10 December 2021

Our Ref: 34199/06

Your Ref: Y/127/21/RES

Land off Bilsham Road, Yapton.

| SCALE:  | 1:100 (A1 ORIGINAL)          | DRAWING: | 3B5P Type D & 2B4P Type B - Terrace Full Plans & Elevations |

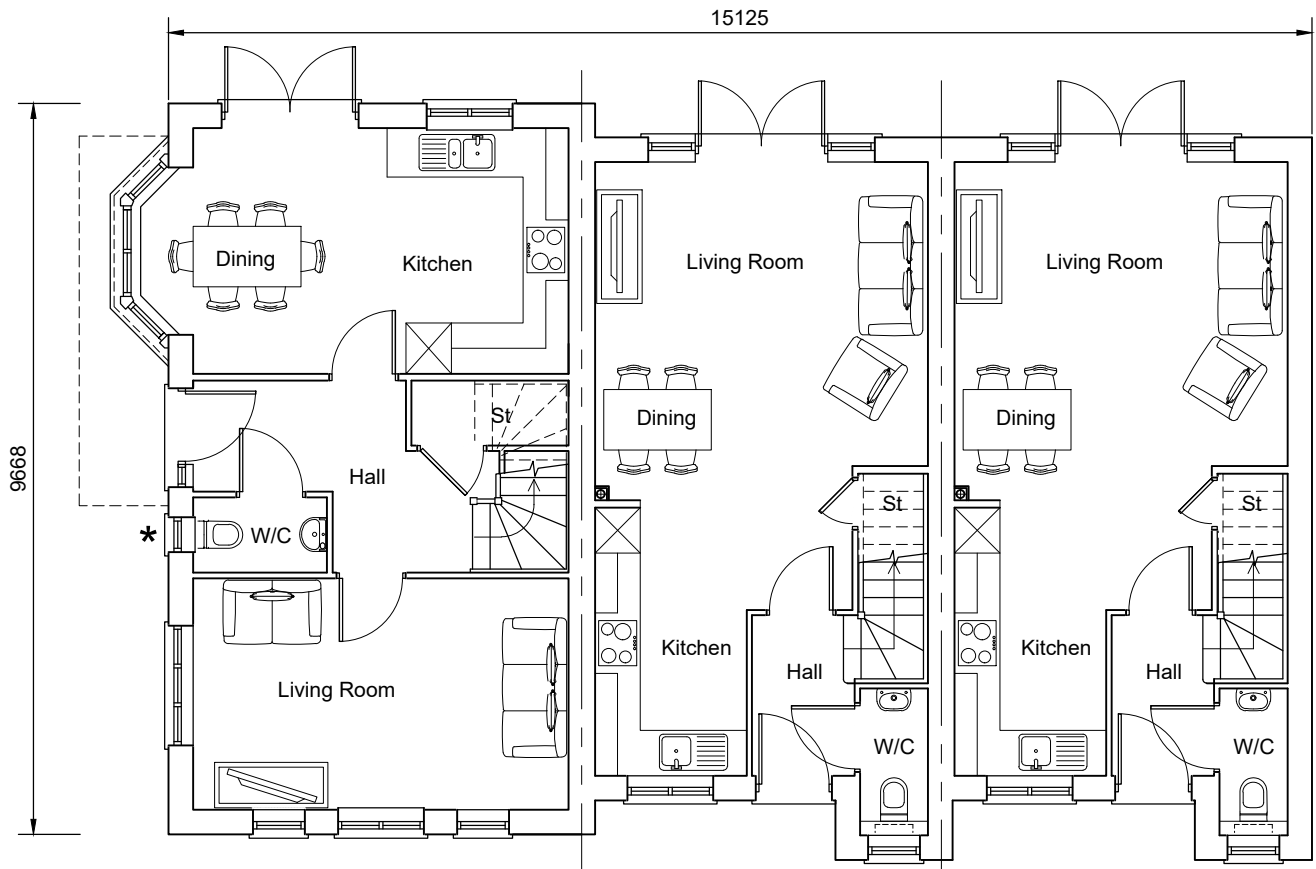
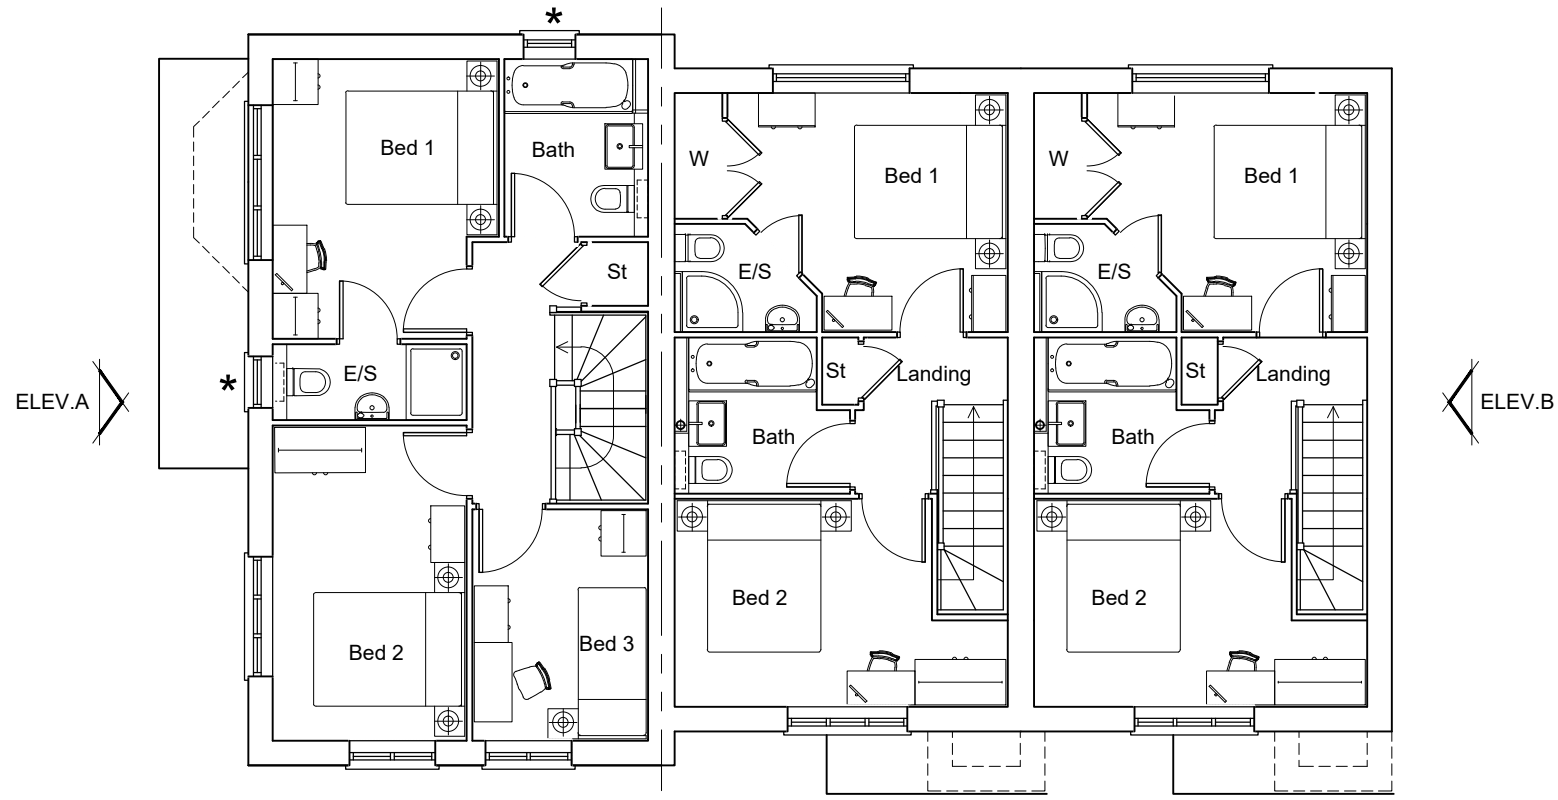
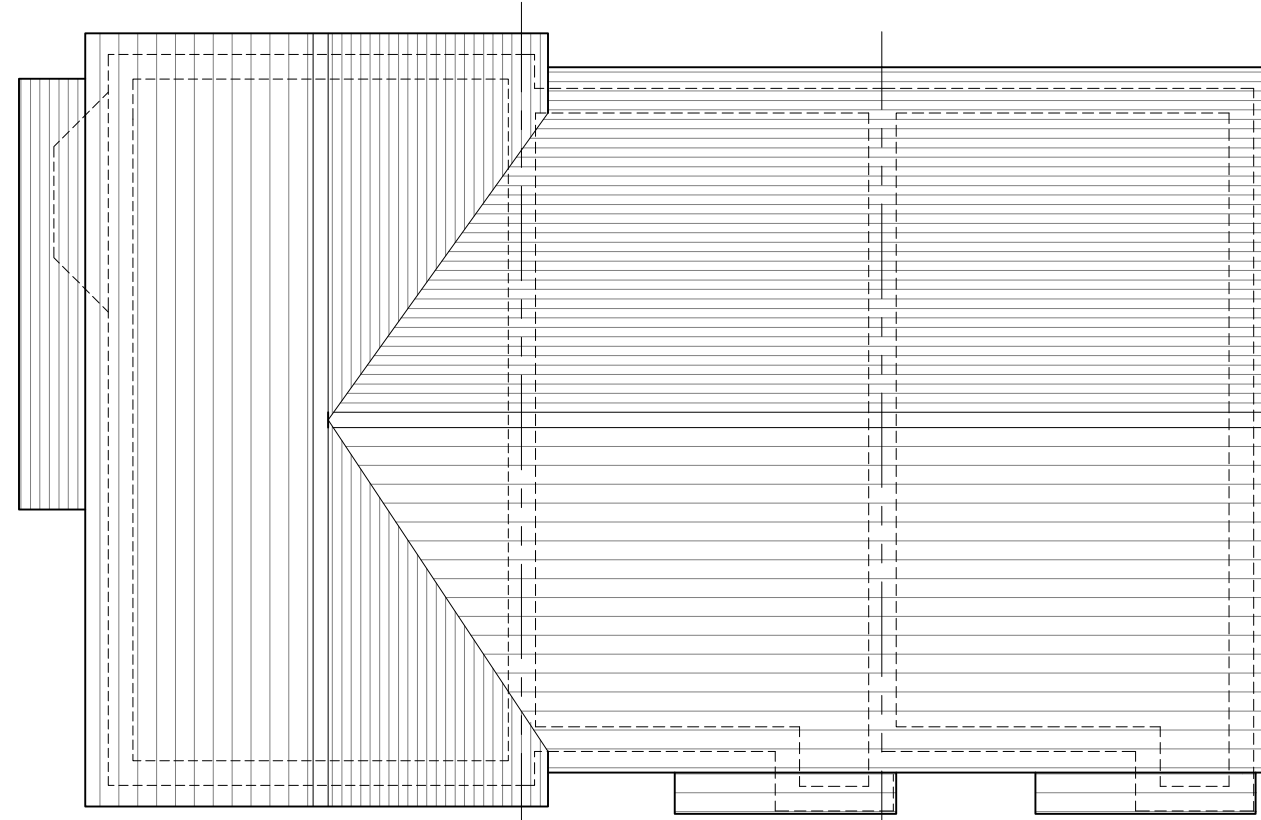
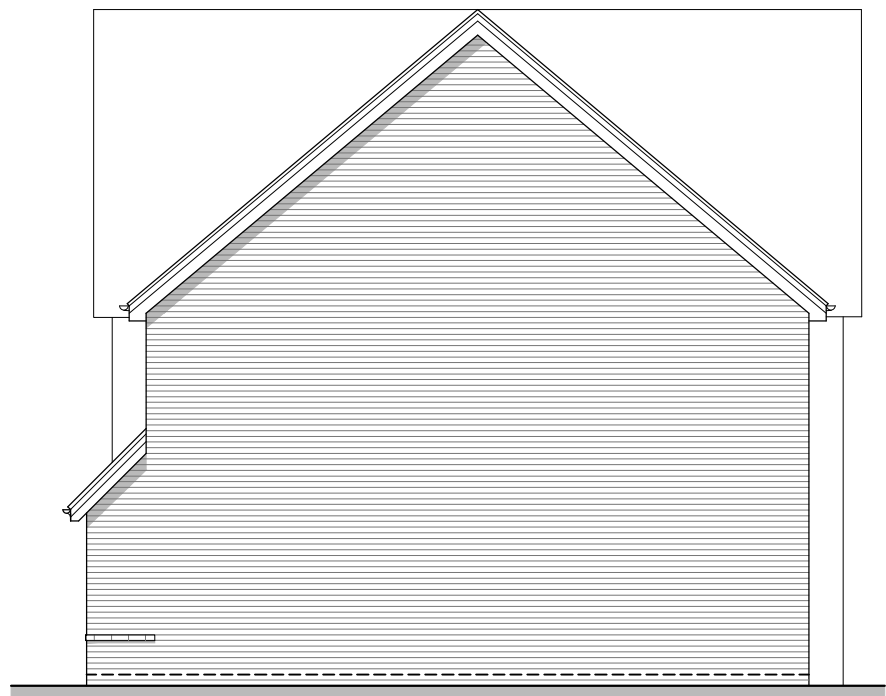
Yapton Parish Council and the Case Officer have noted the streetscene showing the open green space and noted the difference in the elevations between Barratts and the Site. In response to these comments, the boarding on the Drove character area has been amended to show some off white boarding to blend in with the neighbouring scheme. In addition to this, the building materials layout and streetscenes have been updated and the new plan numbers are listed below.
